Planning Application Ref: EG/13/19/T

Location: Clarendon House, Church Lane, Eastergate, PO20 3UT

Description of works: Crown reduction of 2m to 1no. walnut Tree

Extract from TPO/1/91/EG

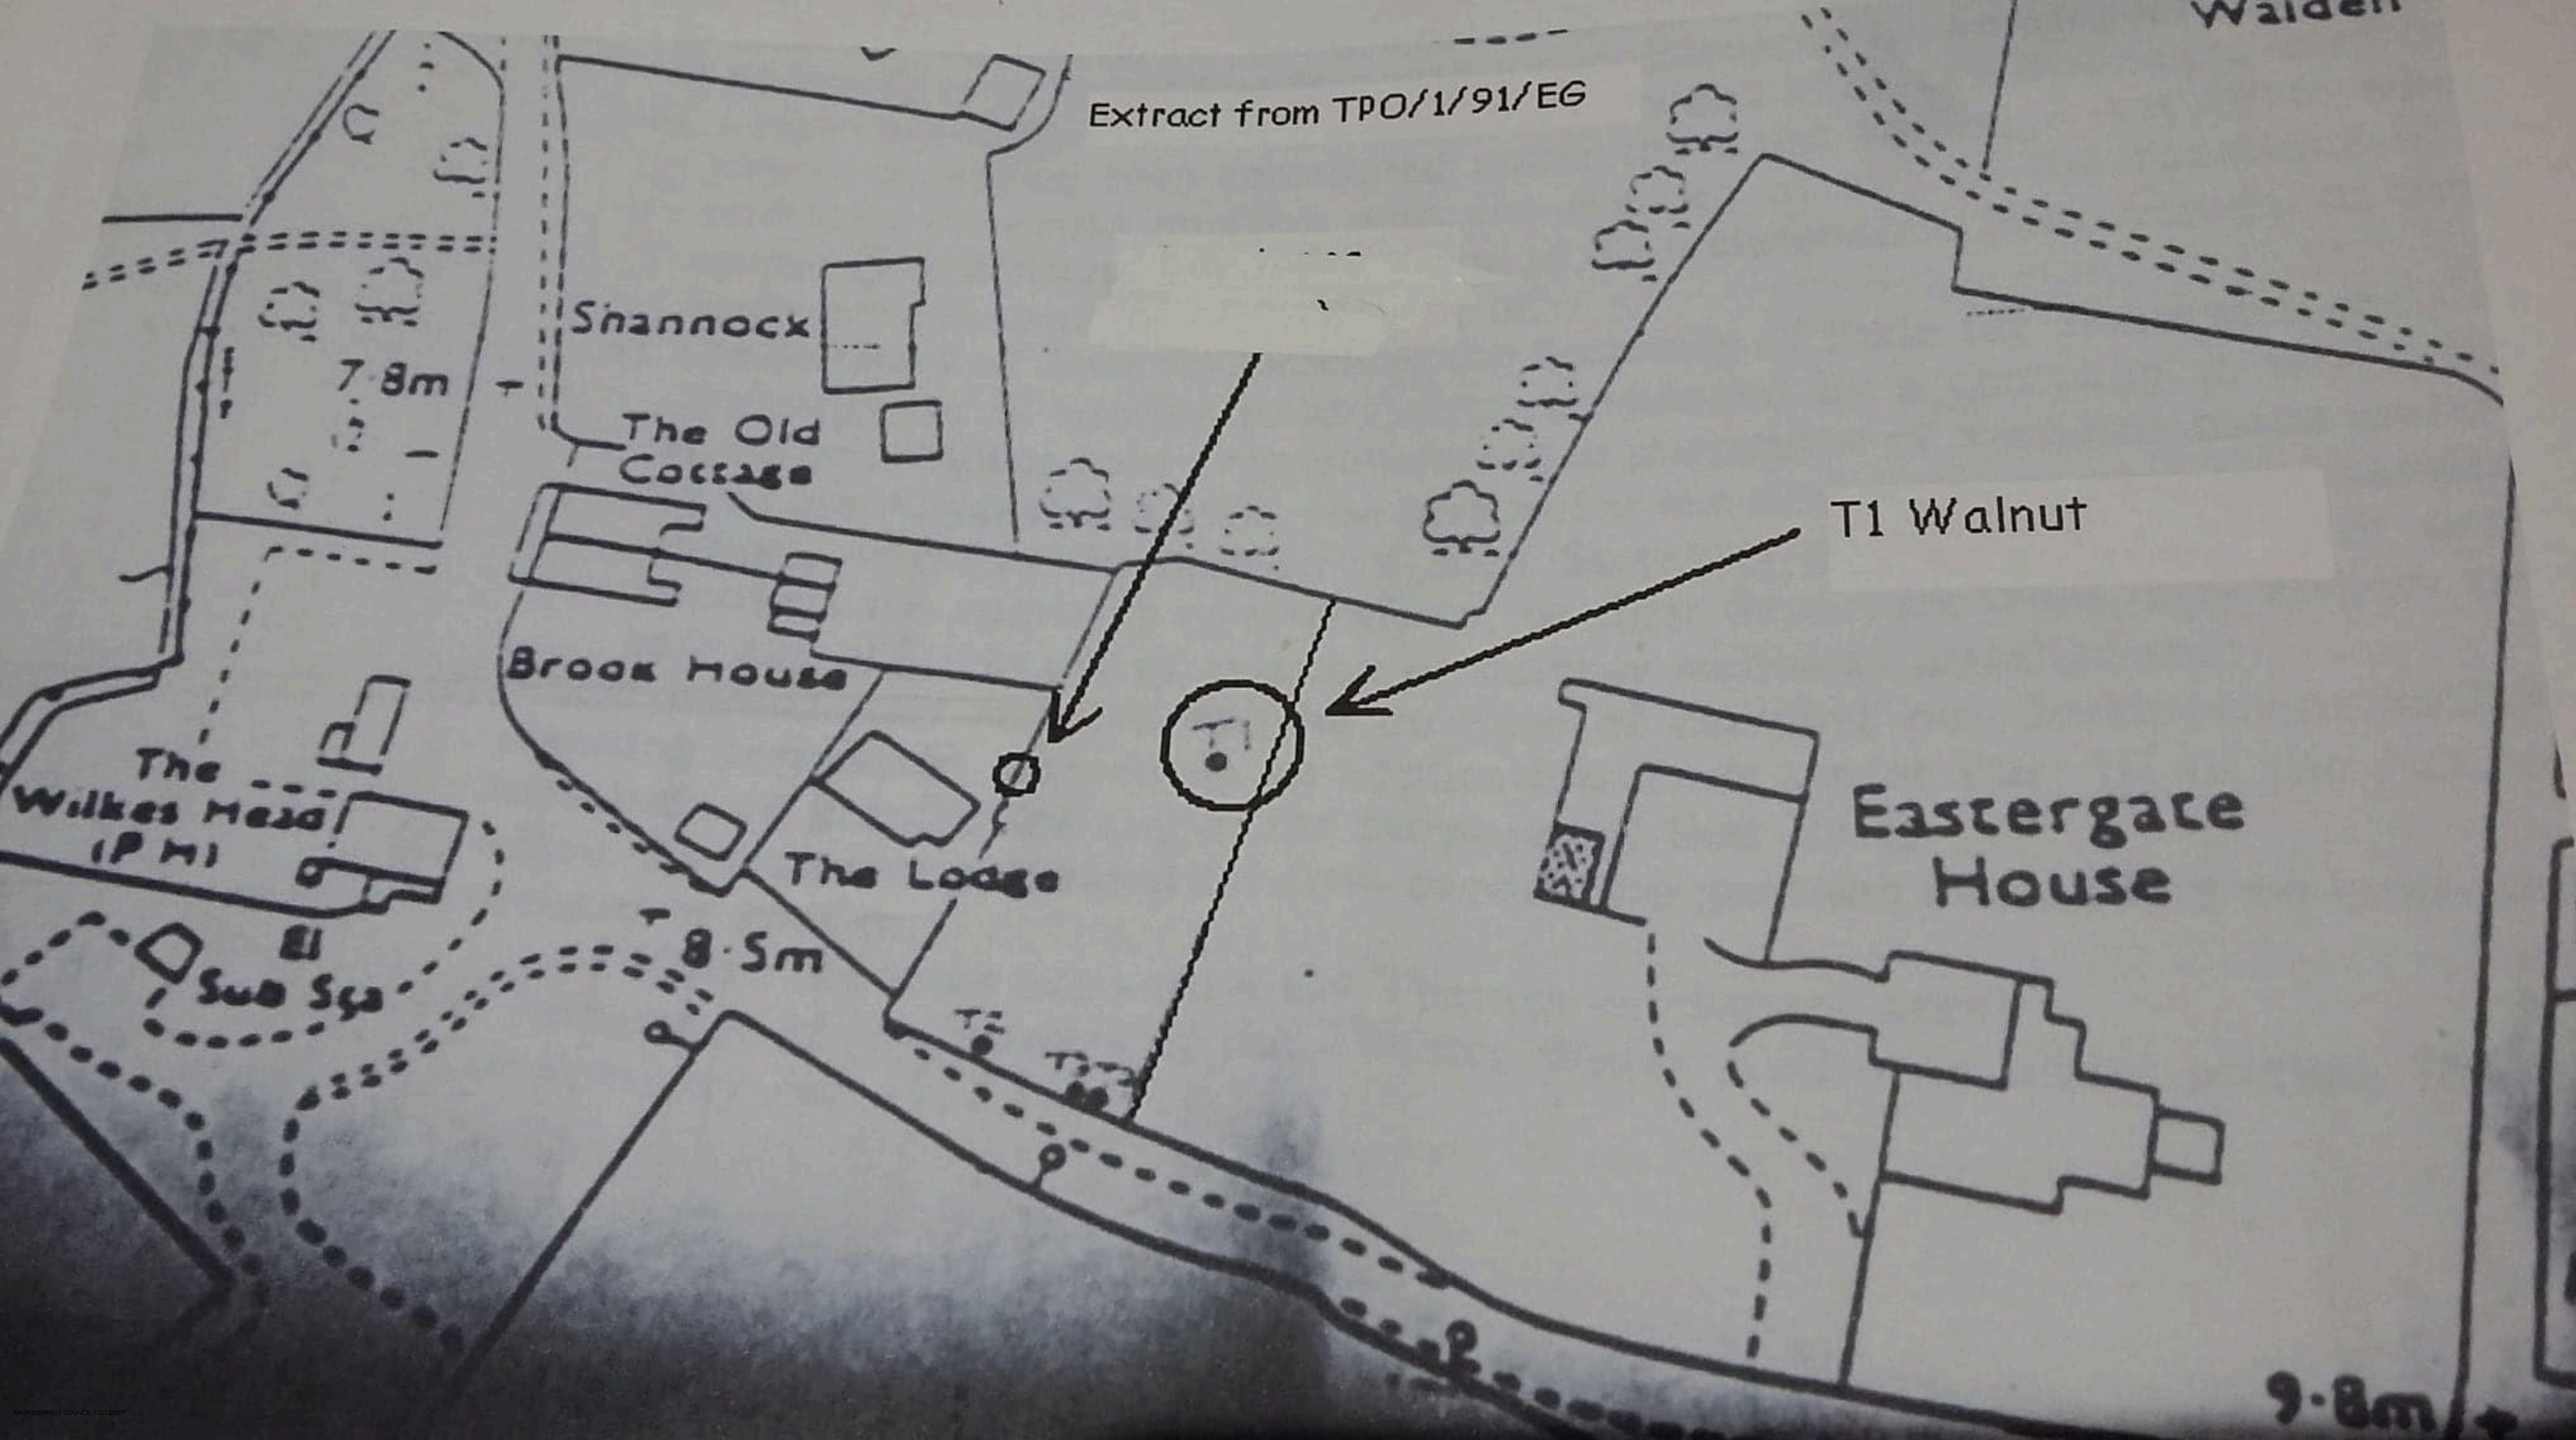
Common walnut / *Juglans regia* Height: Approx. 11m Average spread: 5m Age class: Mature

- This tree appears to be in a fine physiological state with an attractive crown profile. Historic reduction work (last granted consent – October 2014) has allowed numerous decay zones and cavities to develop in the limb/branch framework. It has responded with approximately 2-3metres of new growth from established knuckles.
- It is visible from adjacent property but only with difficulty from the nearest public highway.

- The work proposed is justified on arboricultural grounds as it seeks to perpetuate an agreed cycle of pruning which will significantly reduce the likelihood of large limb/branch failure.
- There will be no significant loss of public amenity on completion of the proposed works.

- I recommend **CONSENT** for this application, subject to the following conditions:

- Where whole branches are to be removed and final cuts made close to the trunk or branch union they are to be made as shown in Figure 2 of BS3998:2010
- Where branches are to be shortened back the final cuts are to be made at the correct angle shown in BS3998:2010 and adjacent to a live bud or lateral.
- The removal of crown material which has developed since the last operation must be done sympathetically and with respect to established 'knuckles' so as not to extend beyond the point of origin.
- The long-term vitality of this tree is best respected when significant pruning work such as proposed, is undertaken during either the summer (June to August) or mid-winter (mid-December to mid-February) periods. The work proposed must only be undertaken during these periods.
